# KITTITAS COUNTY

## DEPARTMENT OF PUBLIC WORKS

### MEMORANDUM

TO: All Staff  
FROM: Public Works Planning Review Team  
DATE: February 1, 2021  
SUBJECT: BL-21-00001 Stutz

SHEET
2
OF
2

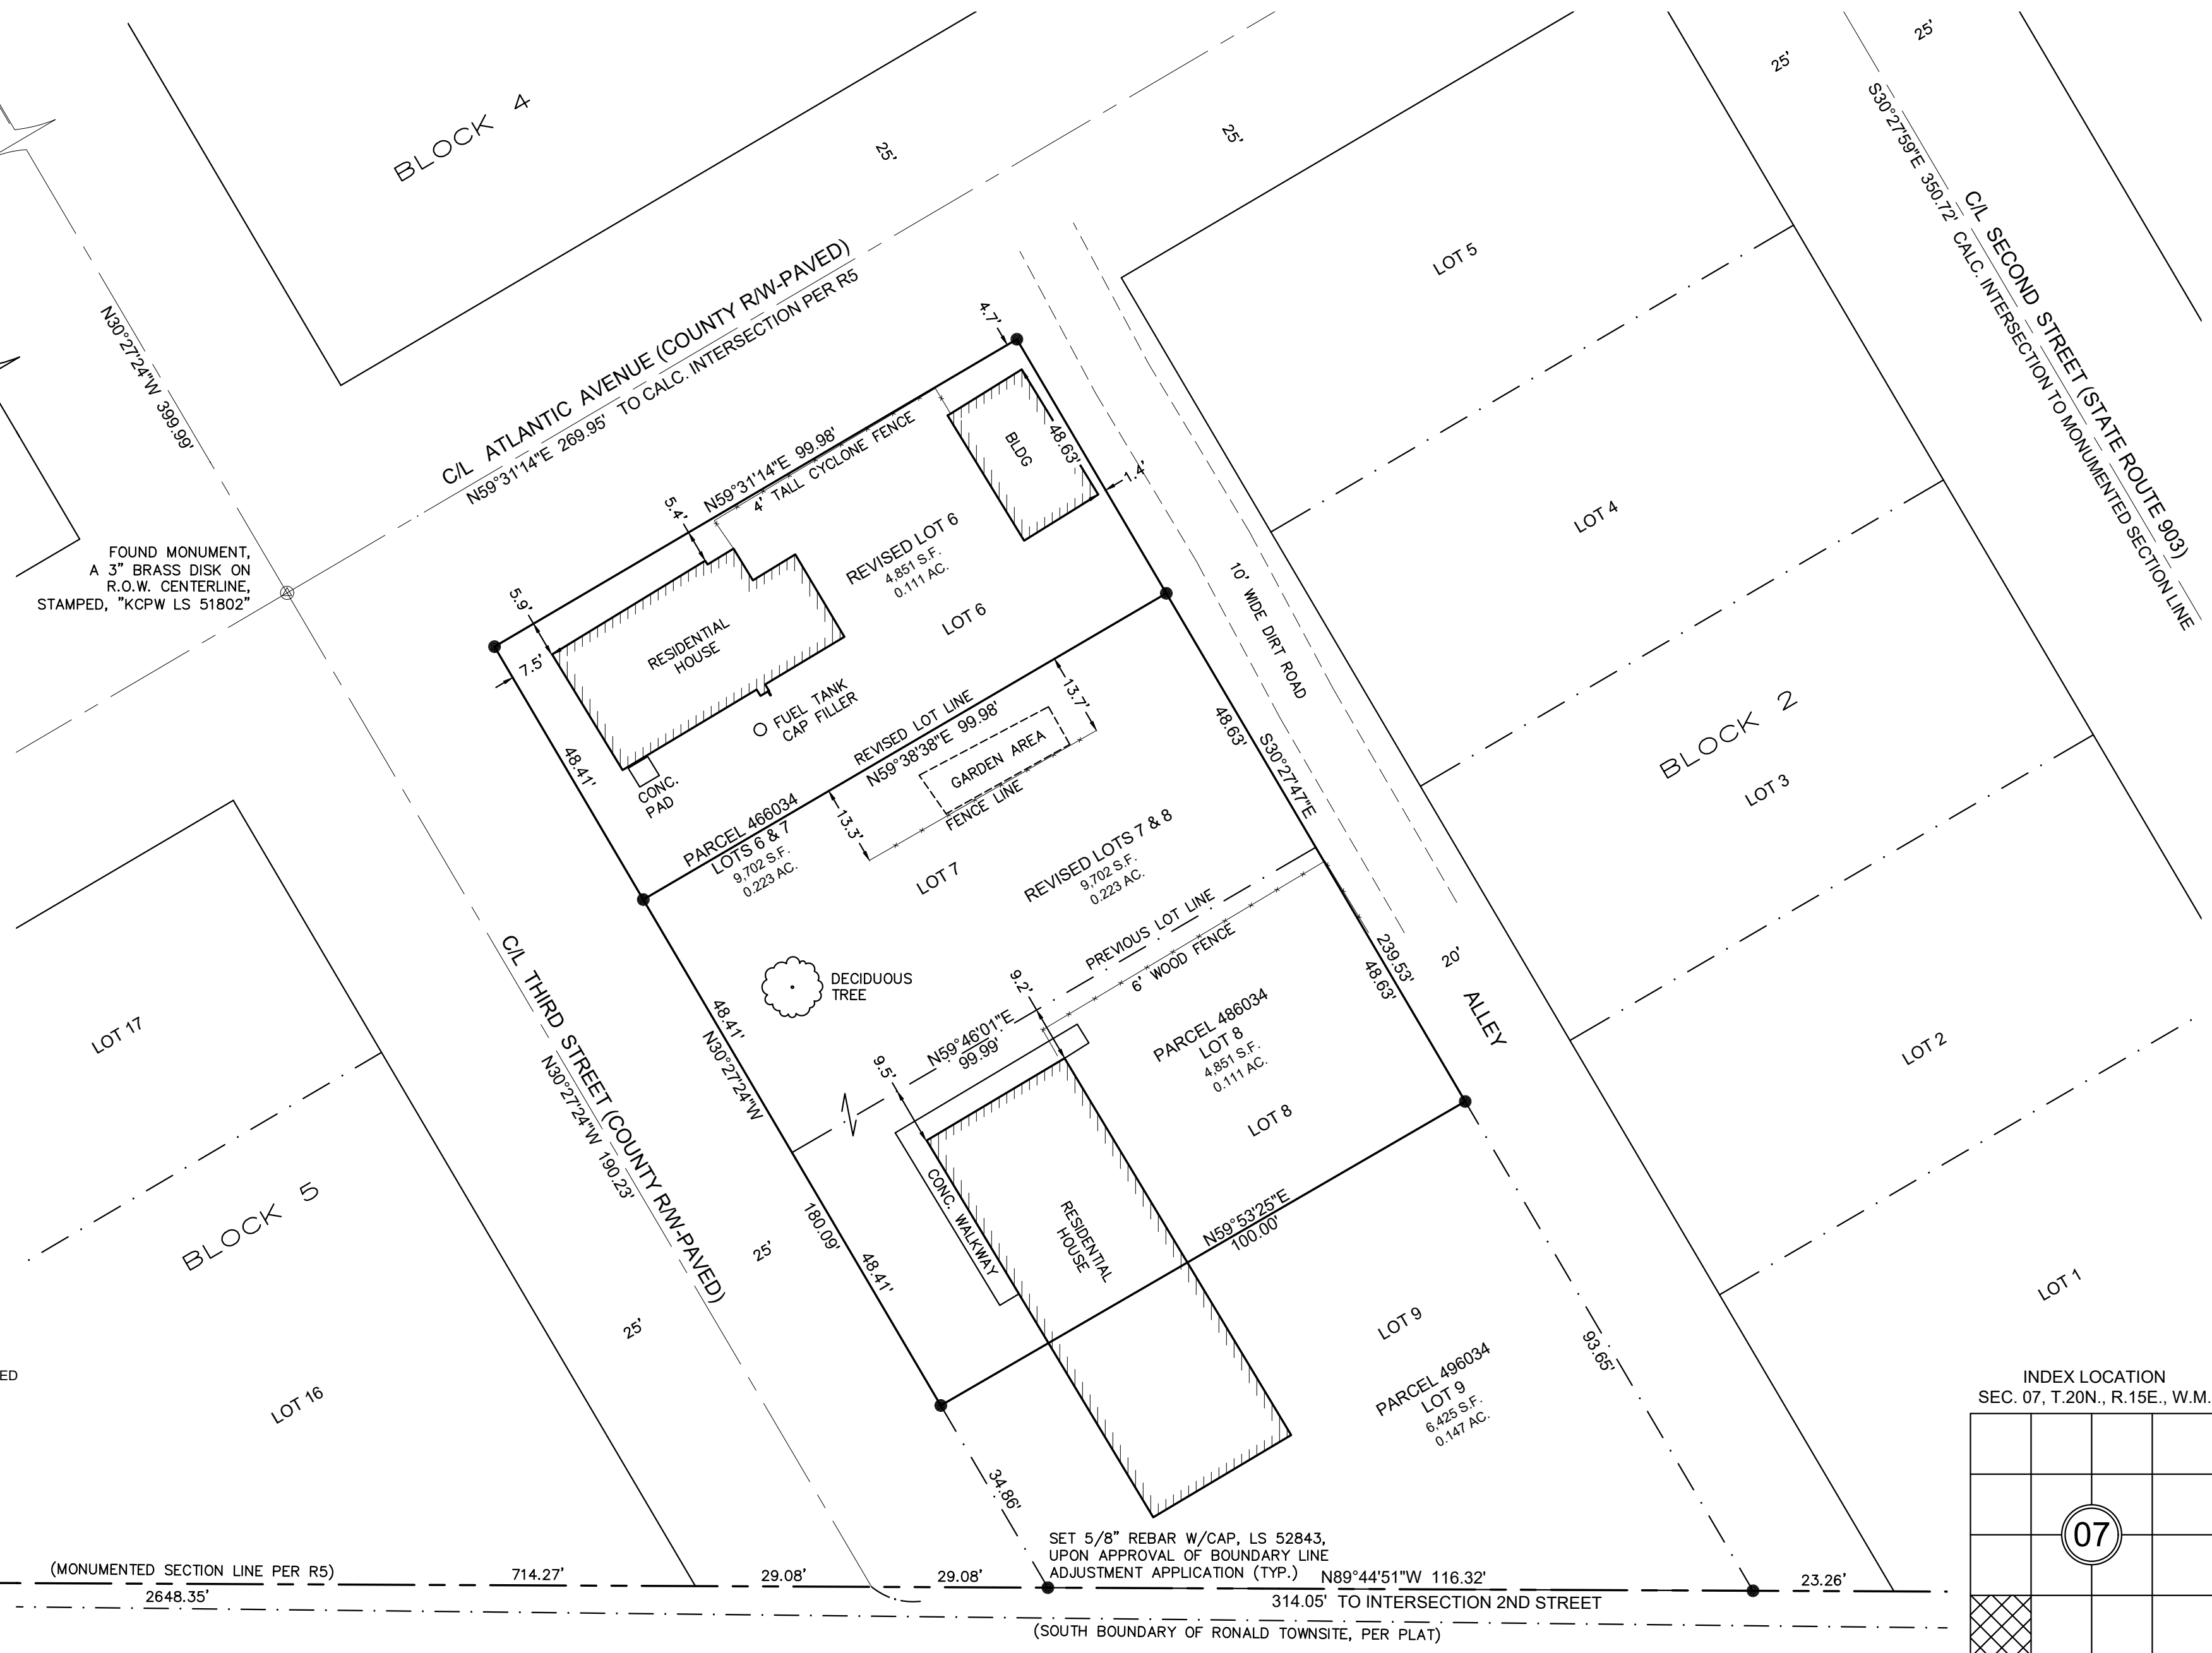
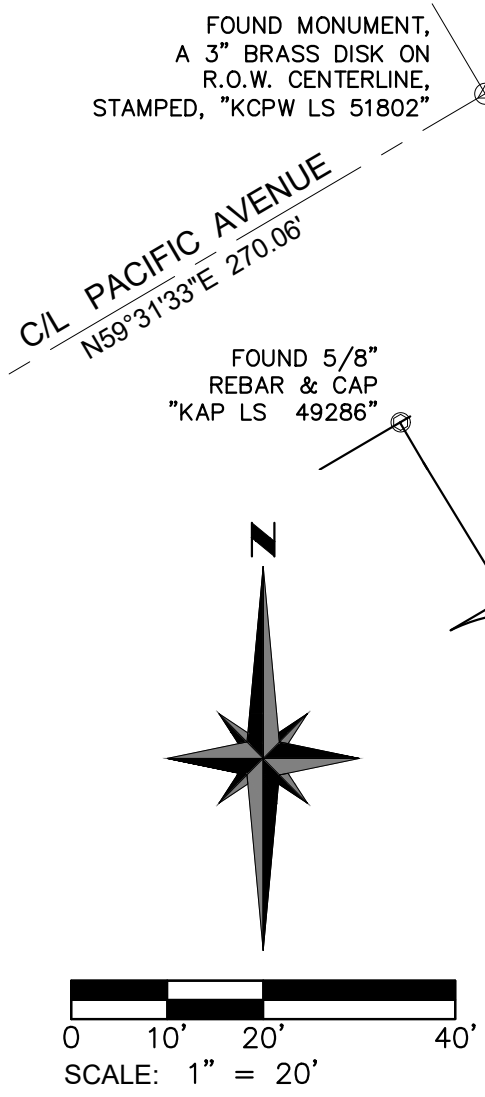
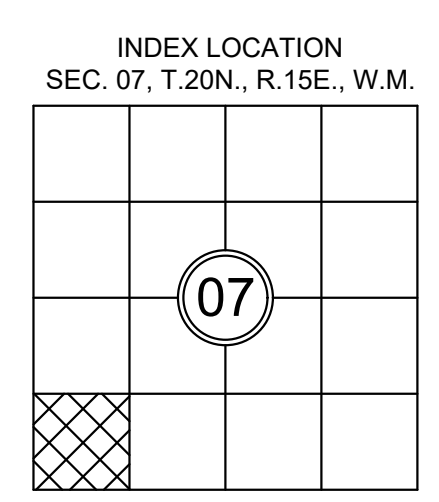
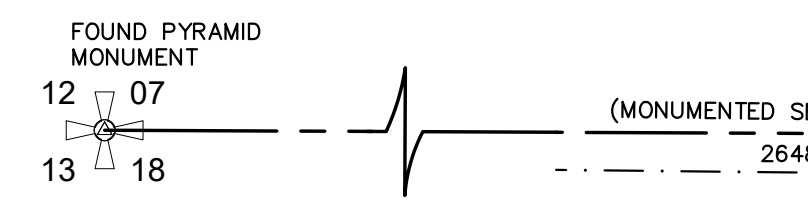
#### **Comments (not required):**

1. Legend is missing
2. Road ownership and surfacing should be included.  
EX: (Third St-County R/W-Paved)
